DA/871/2010
RDC 10M1460 Vol 2 SYD10/00569
Nagalingam Raveendrarajan (EP)
8849 2540

**SYDNEY
REGIONAL
DEVELOPMENT
ADVISORY
COMMITTEE**

**PROPOSED STABLES AND TRAINING PRECINCT AT,
RANDWICK RACECOURSE, 77-79 ALISON ROAD, RANDWICK**

SITE PLAN
STABLES & TRAINING FACILITIES
AJC RANDWICK RACECOURSE

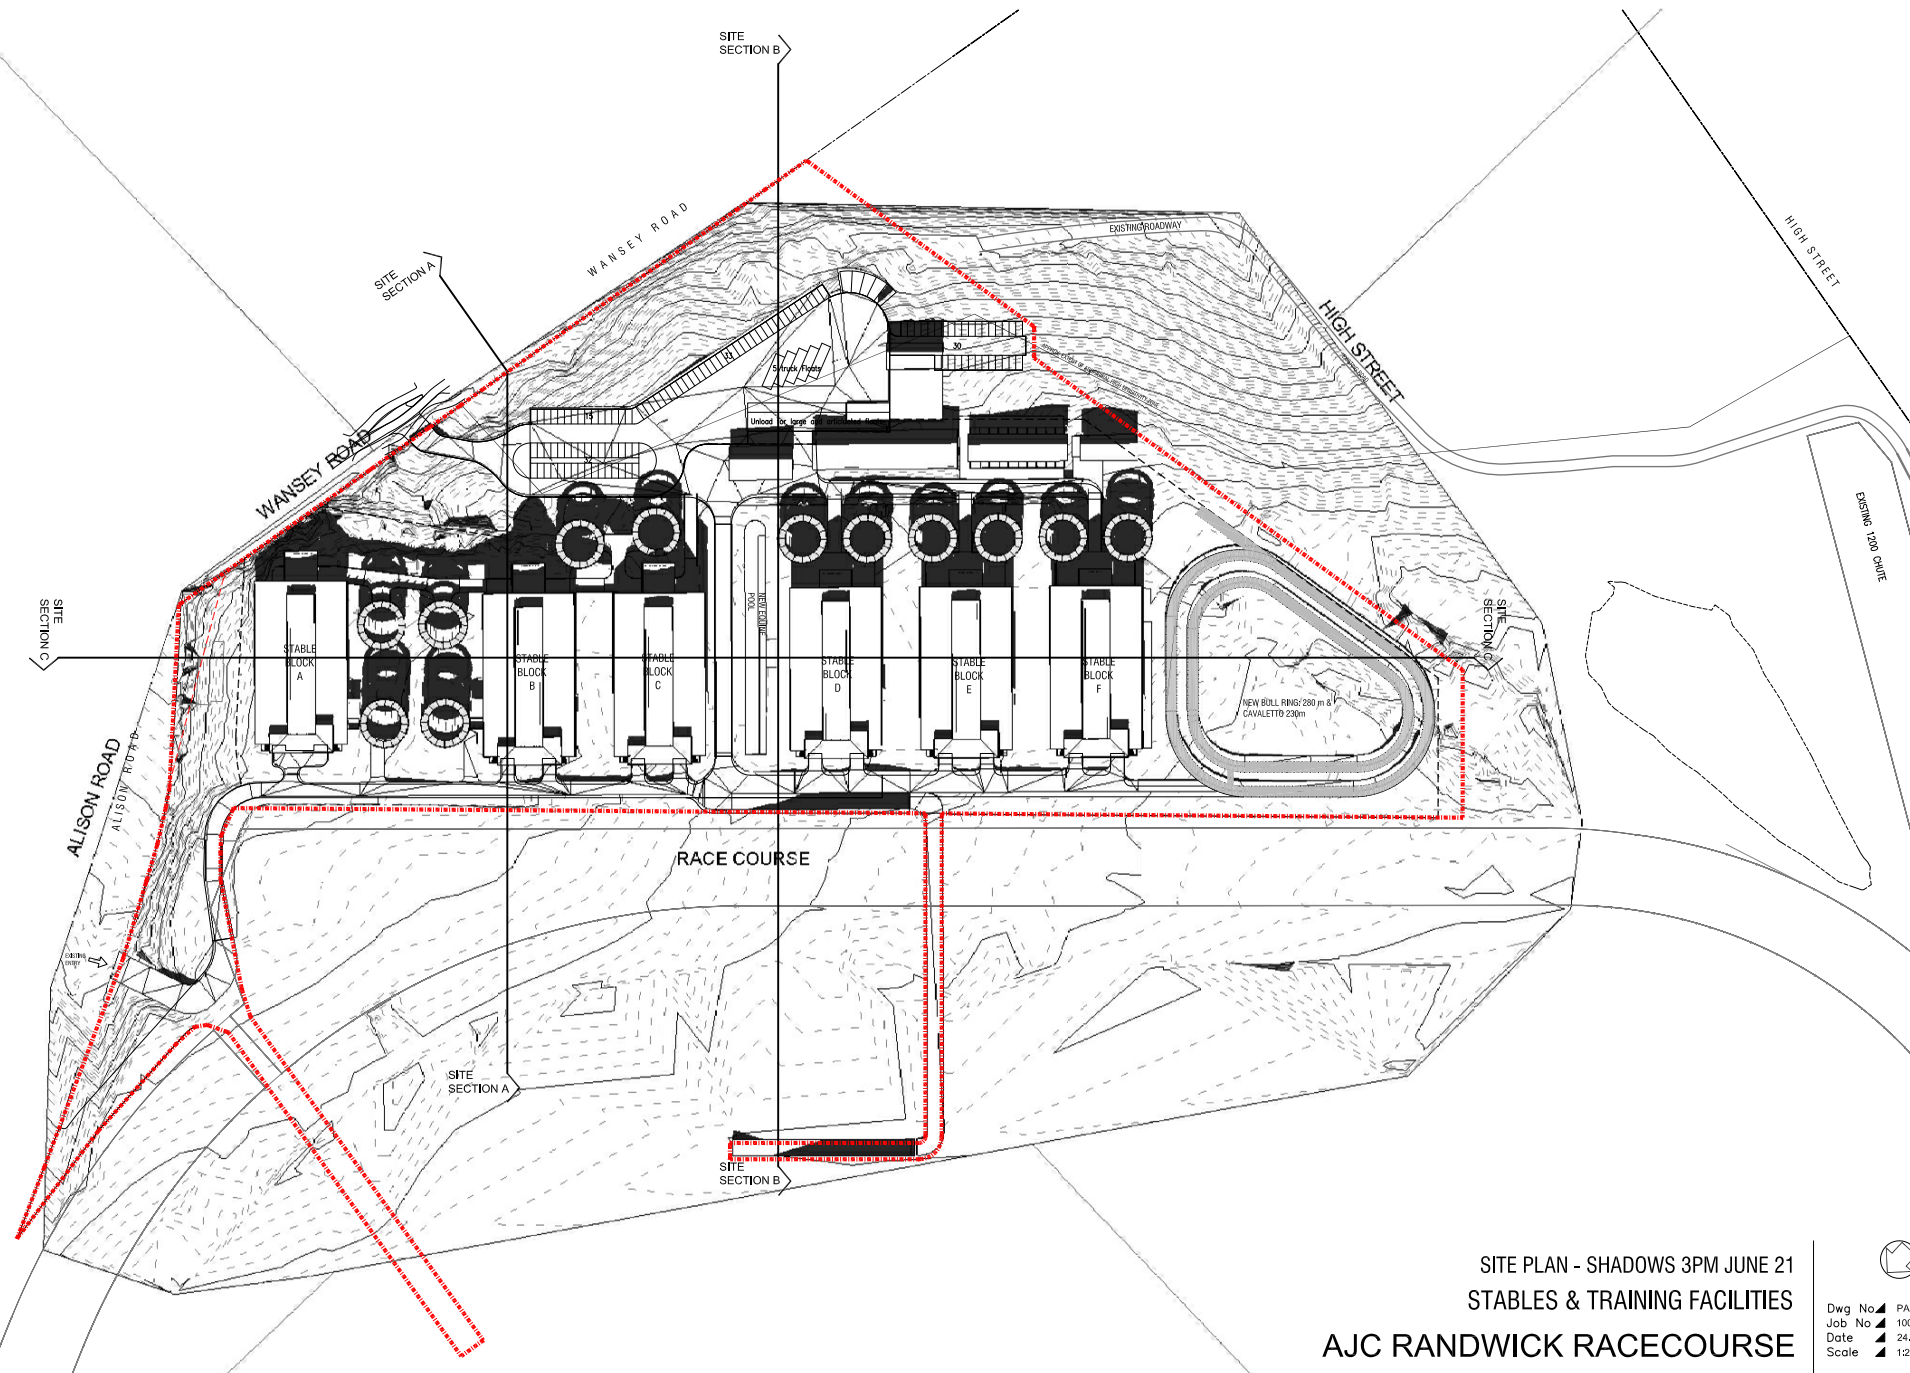
4. The use of the narrow/southern access driveway on Alison Road (i.e. access adjacent to the brick cottage/caretakers house) shall be banned except in race events in accordance to the approved Special Event Transport Management Plan. Signage shall be installed to enforce this requirement. Use of the wider/northern access driveway on Alison Road can be maintained provided parking on the approach to this access is banned.

5. Both existing access driveways on Alison Road need to comply with AS2890.1 and AS2890.2 for large vehicles. It is noted that due to the gradient of the driveways inside the site, existing fencing and existing vegetation (trees), it is unlikely that the driveways meet the required sight distance to the regional shared path along the Alison Road site frontage.

The access driveways shall be reviewed and if required re-designed and re-constructed to comply with AS2890.1 and AS2890.2.

8. The layout of the proposed car parking areas, loading docks and access driveway on Wansey Road associated with the subject development (including, grades, turn paths, sight distance requirements, aisle widths, aisle lengths, loading area dimensions and parking bay dimensions) should be in accordance with AS2890.1- 2004 and AS2890.2 – 2002 for large vehicles.
